Application No: LU/238/20/OUT
Site Address: Land west of Bridge Road Roundabout Littlehampton BN17 5DF
Description of works: Outline planning permission with some matters reserved for demolition of existing treatment works and redevelopment of a former camp site on the edge of the River Arun to provide up to 105 homes, 100sqm of A1 Shops use, 220sqm of A3 Restaurant use and 420m of pontoons to provide approximately 32 leisure moorings along with associated landscaping, sluice gate, flood defence works, car parking and highways works, including access. This application also lies within the parish of Clymping, may affect a Public Footpath and is a Departure from the Development Plan.

Thank you for your internet representation made on 14th October 2020 which has been recorded as an objection with the comments as follows:

Neil Crowther
Group Head of Planning

ITB3164-GA-009 Rev B

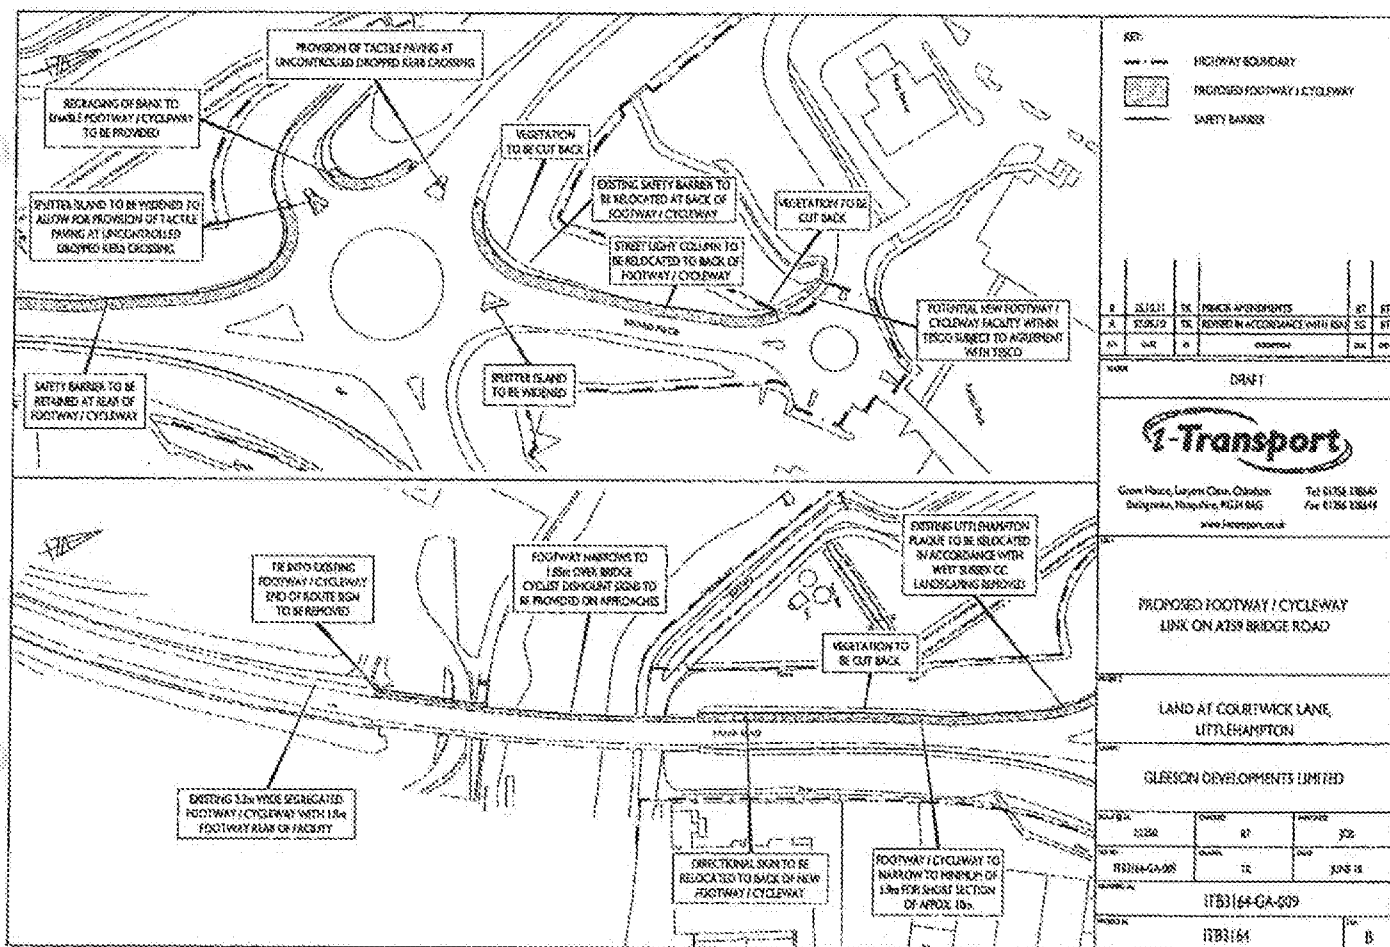
The highway in this location is national speed limit and therefore requires controlled crossings at both the entrance to the new development and the proposed crossing of the a259, both indicated as uncontrolled crossings. In addition, the bridge over the River Arun requires the railing increased in height rather than a sign indicating cyclists should dismount.

Controlled Toucan crossings are the minimum requirement for national speed limit crossings and cyclists dismount signs are no longer applicable given the requirements of LTN 1/20.
